Approved for access by the Solid Waste Department.

Reviewer: Herman Gabeagos

Date: 04-23-24

G & S MEATS FREEZER
SITE DETAILS
REFUSE/SOLID WASTE
1333 ASPEN AVE NW
ALBUQUERQUE, NM 87104
PROJECT #2345

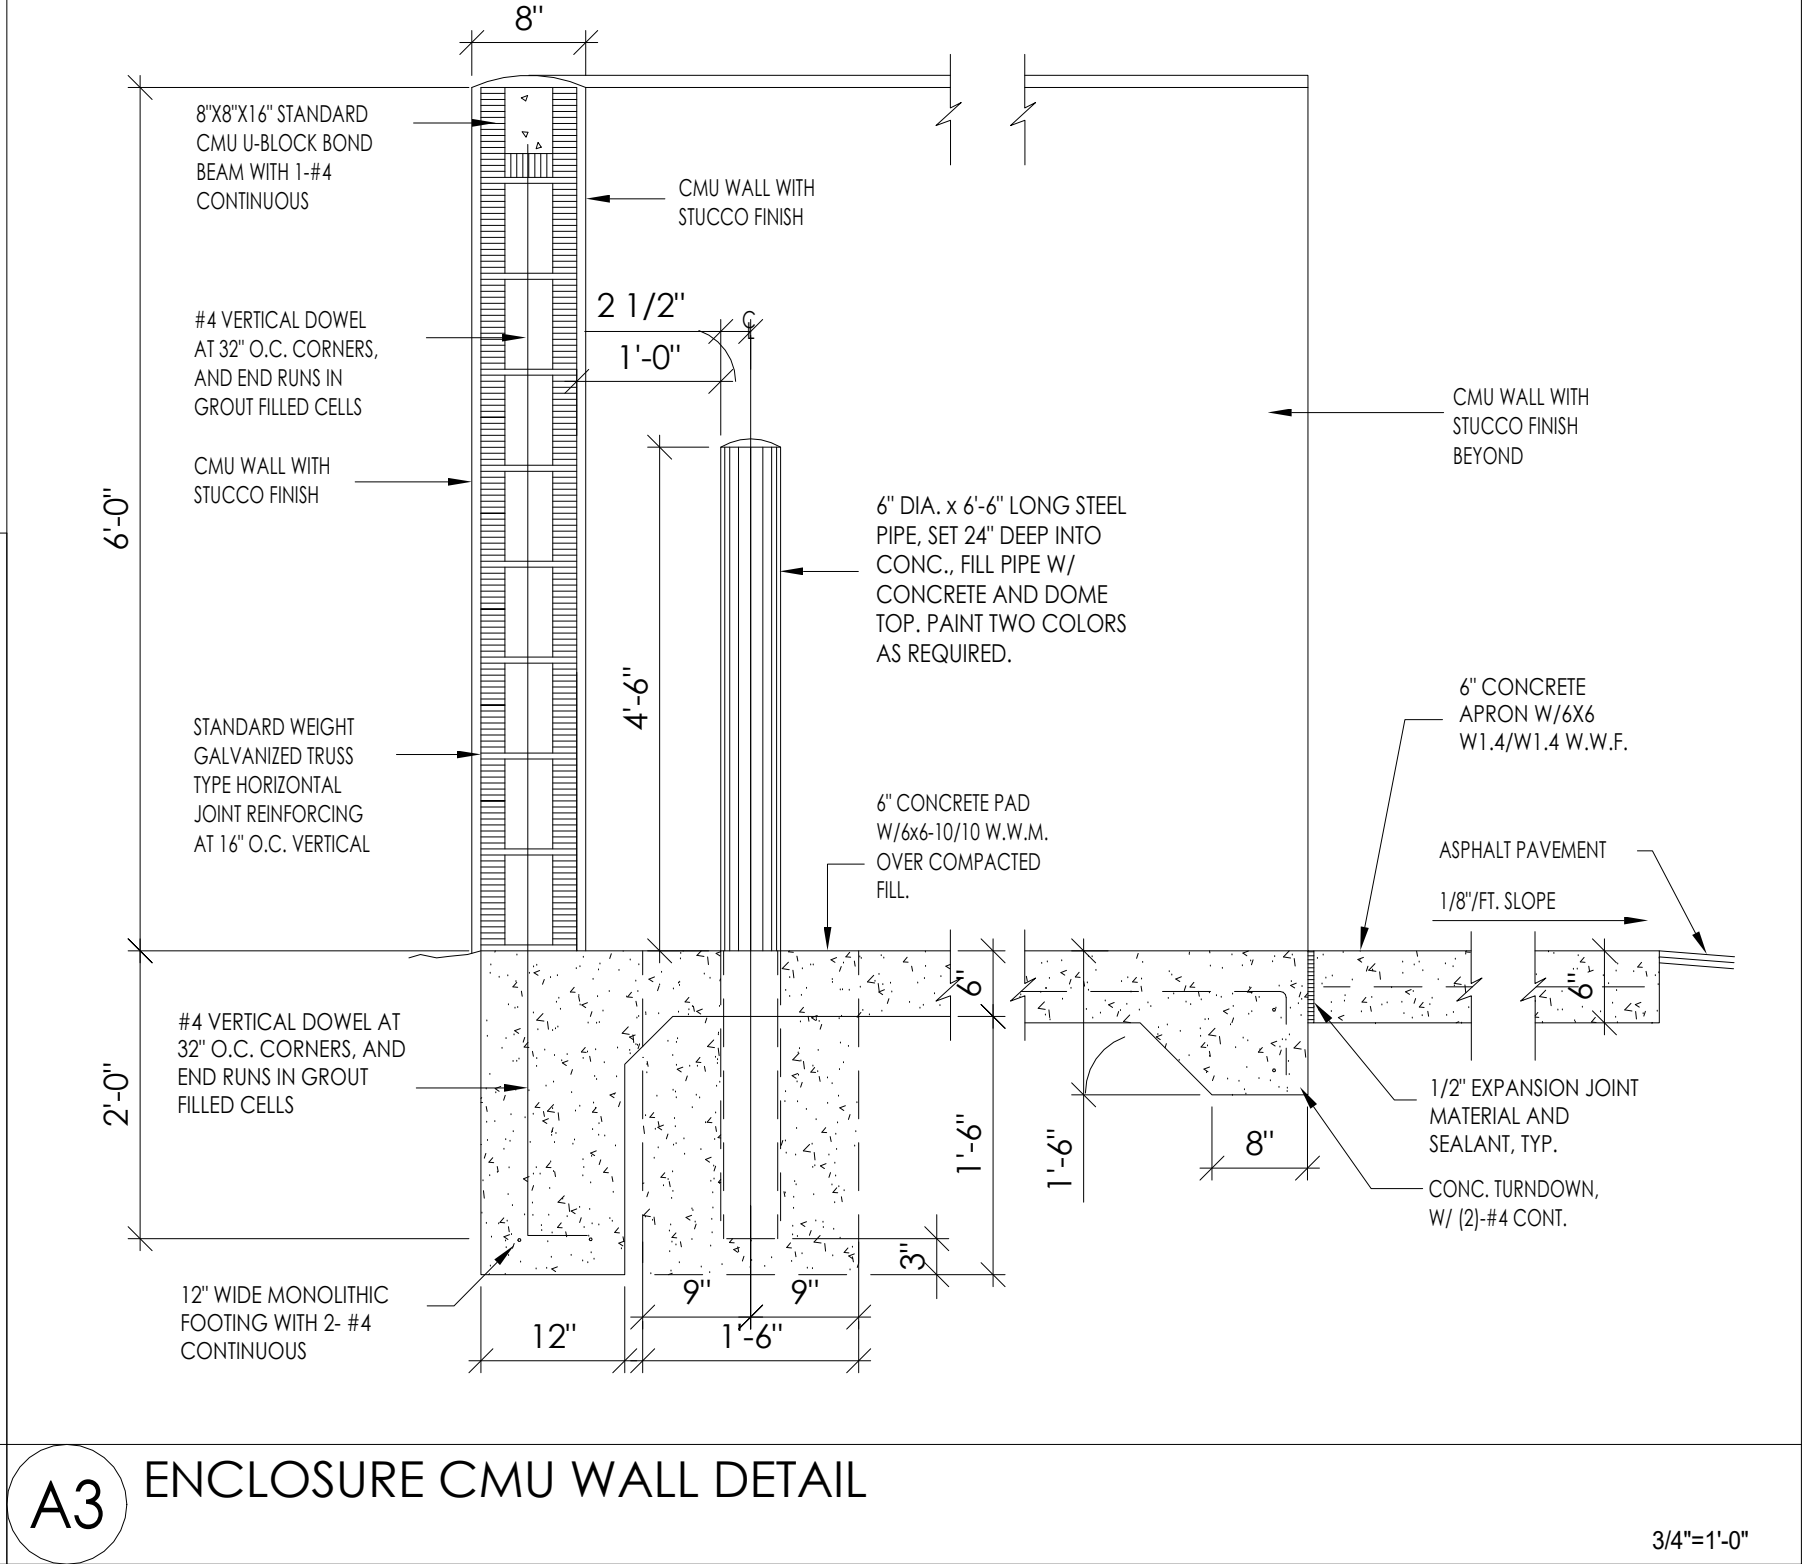
Recycling declined
See manhole note
